Our Case Number: ABP-317660-23

Re: Busconnects Kimmage to city centre core bus corridor scheme
Kimmage, Dublin

Planning application Core bus Corridor Kimmage to City Centre 317660

Programme Title BUSCONNECTS DUBLIN CORE BUS CORRIDORS INFRASTRUCTURE WORKS			
Drawing Title KIMMAGE TO CITY CENTRE CORE BUS CORRIDOR SCHEME GENERAL ARRANGEMENT			
Drawing File Name BCIDD-ROT-GEO_GA-0011_XX_00-DR-CR-0001	Sheet Number 01 of 14	Status A	Rev M01

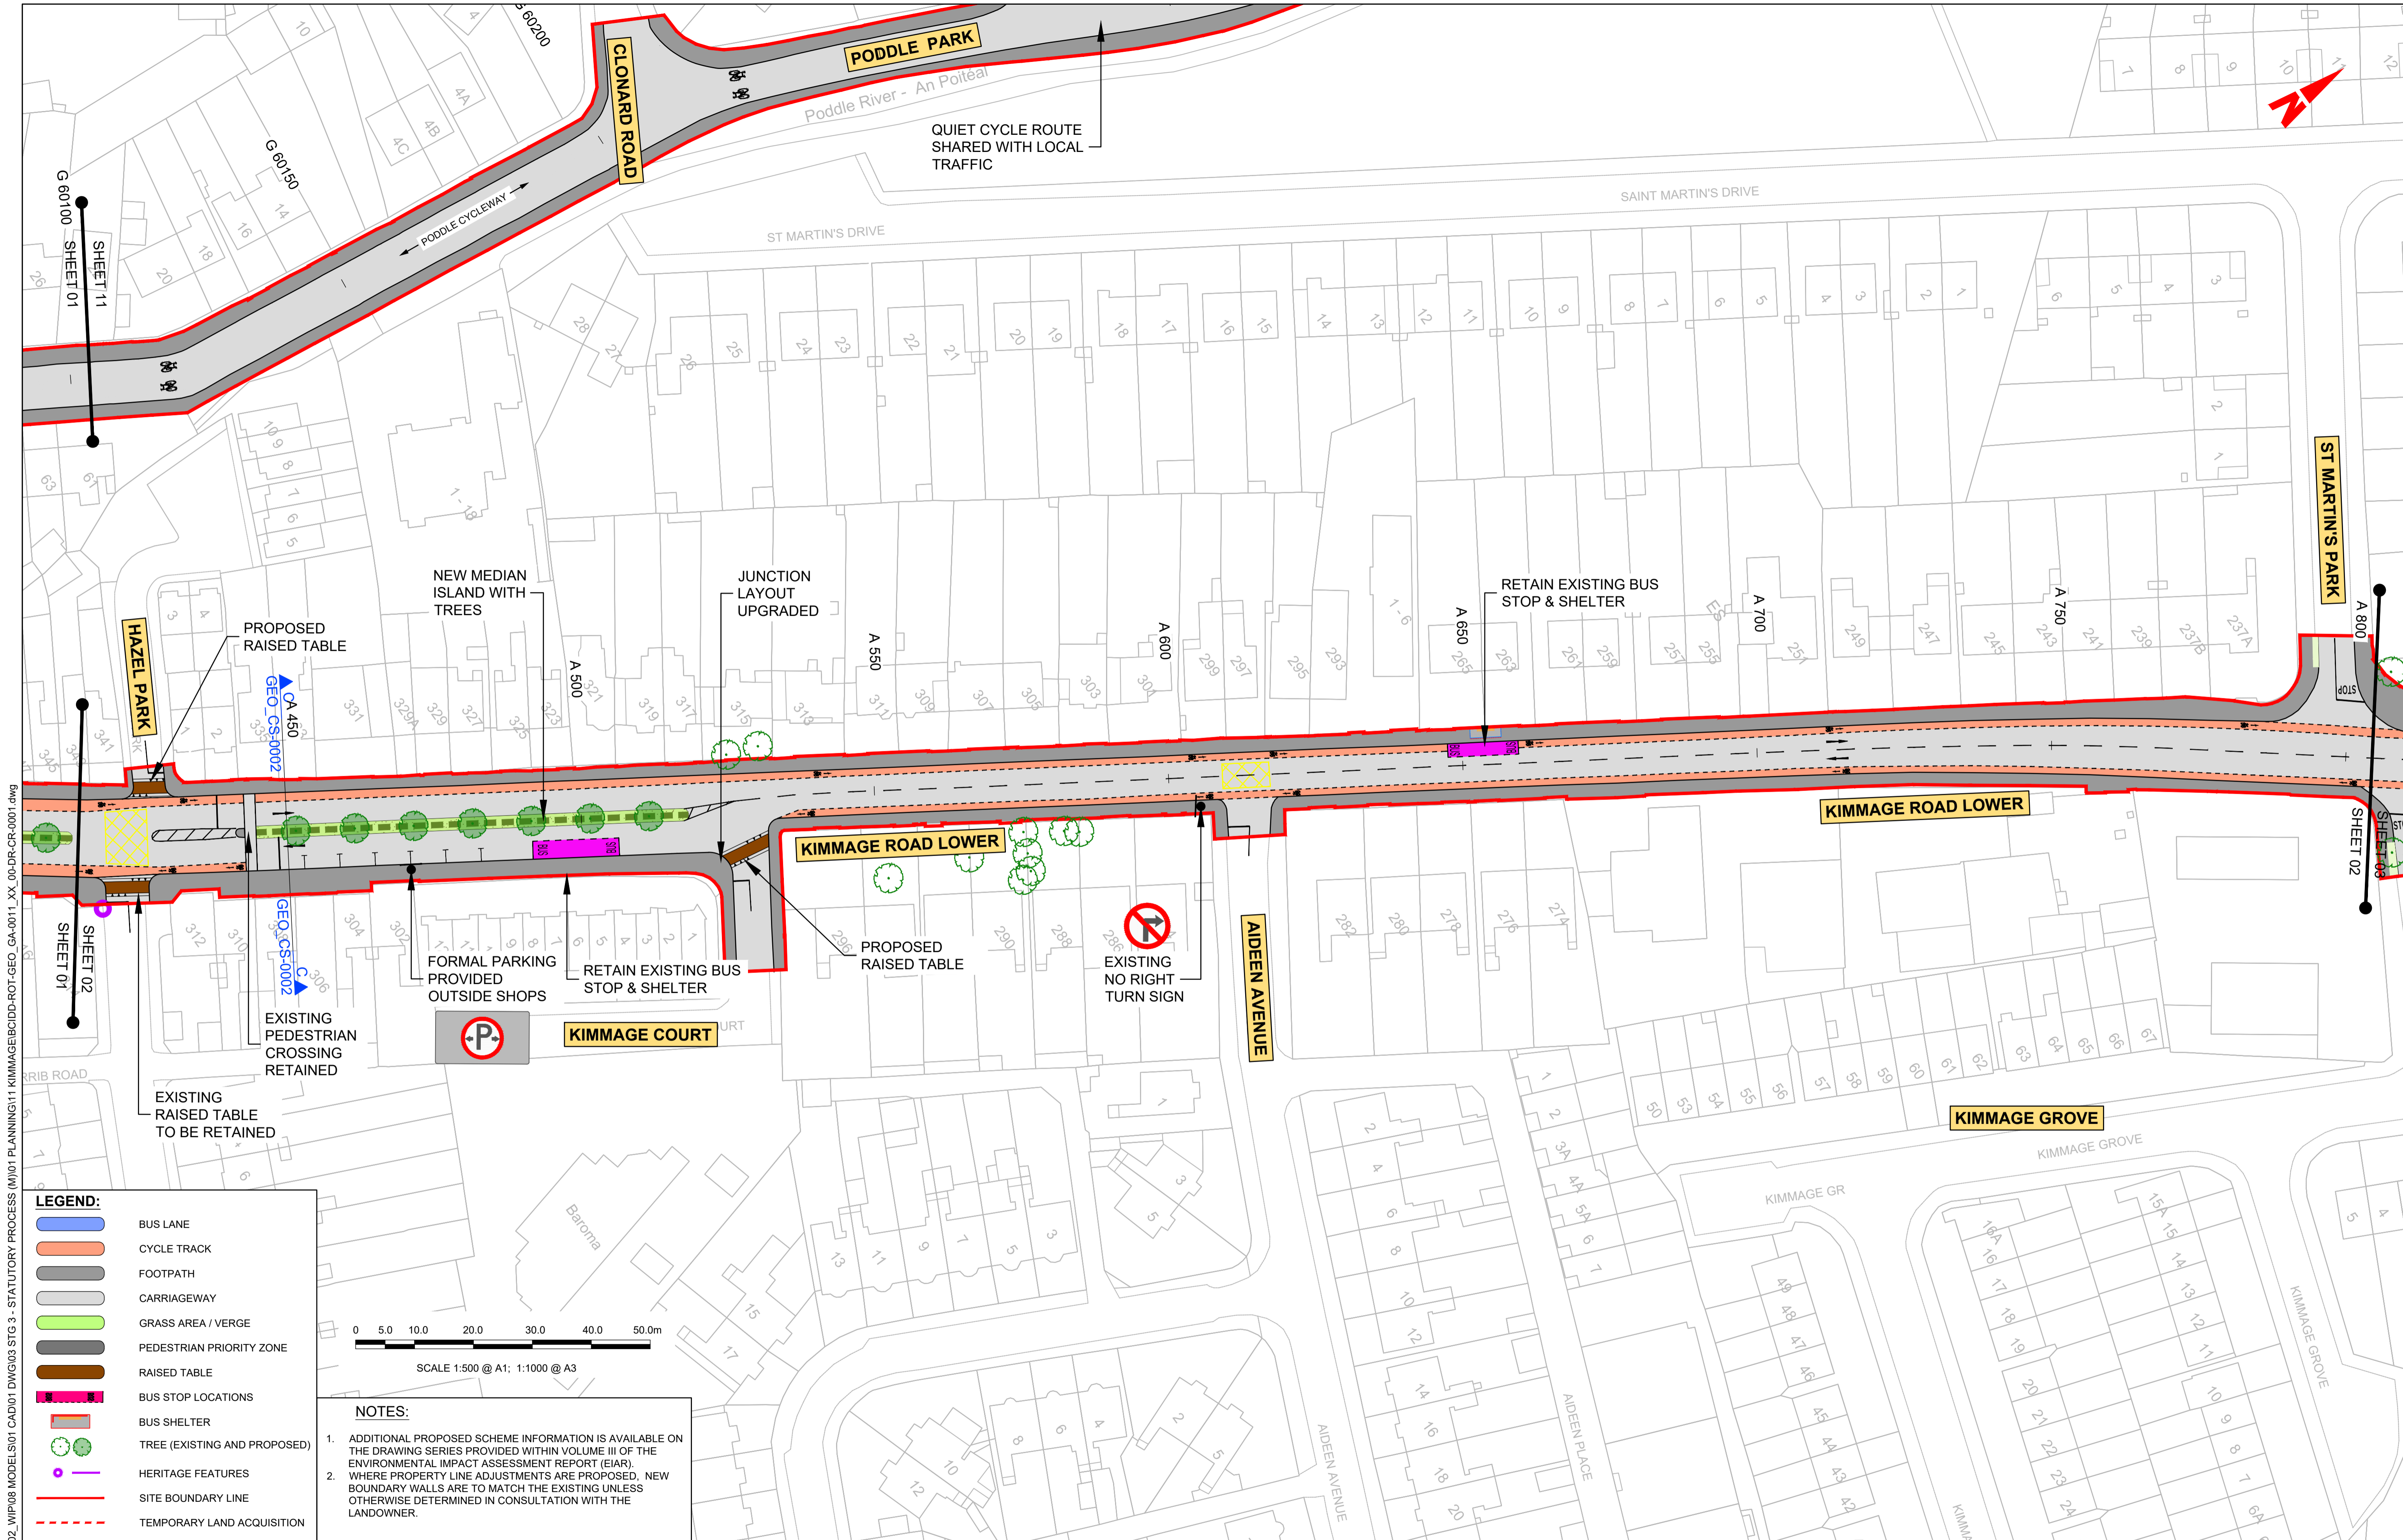
14 Trees at Corrib Road

There is a proposal to add a median island on the corridor close to Corrib Road as per maps 01/02 General Arrangement. This will entail presumably six months of construction (page 3 Construction) and will compromise parking at Tesco Express. This island is in my view unnecessary and should be omitted.

Drawing File Name: BCIDD-ROT-GEO_GA-0011_XX_00-DR-CR-0007
Sheet Number: 07 of 14
Status: A
Rev: M01

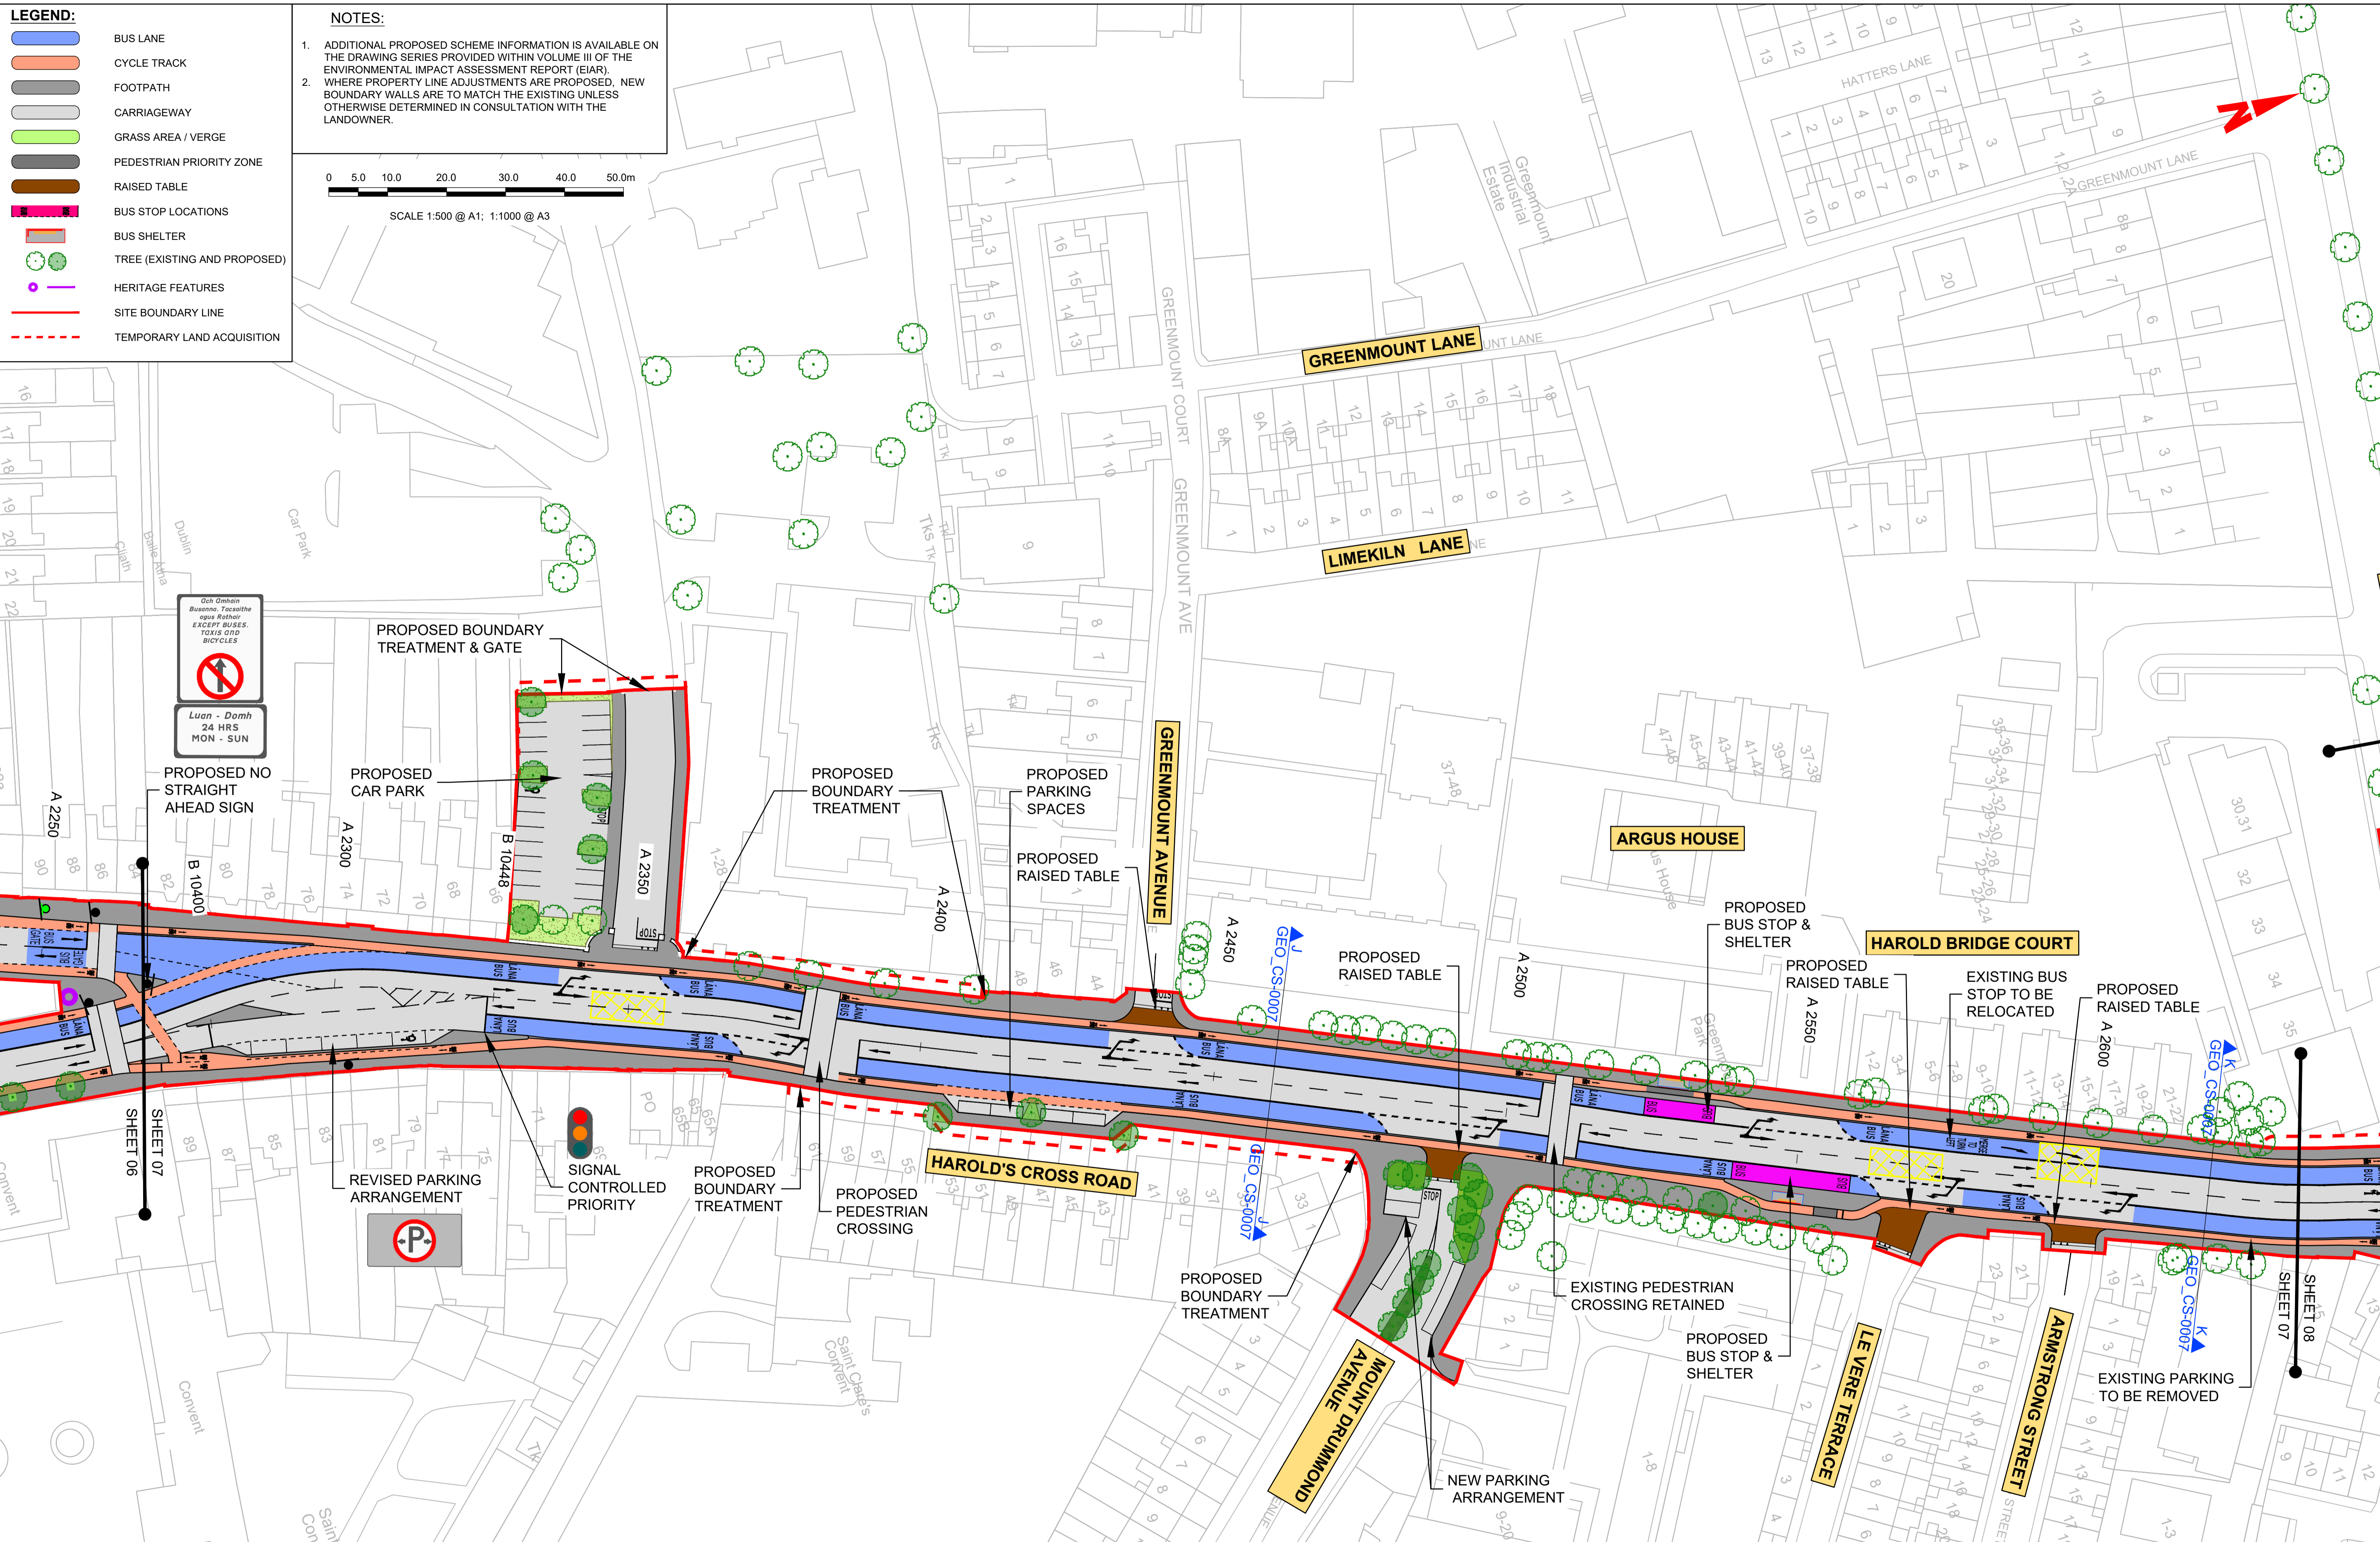
15 CPO opposite Hospice

It's not clear why it's necessary to do a CPO as indicated at map 7. It takes away a lot of very small front gardens. Further the cpo on the Hospice side will take away a very narrow strip in front of the houses there.
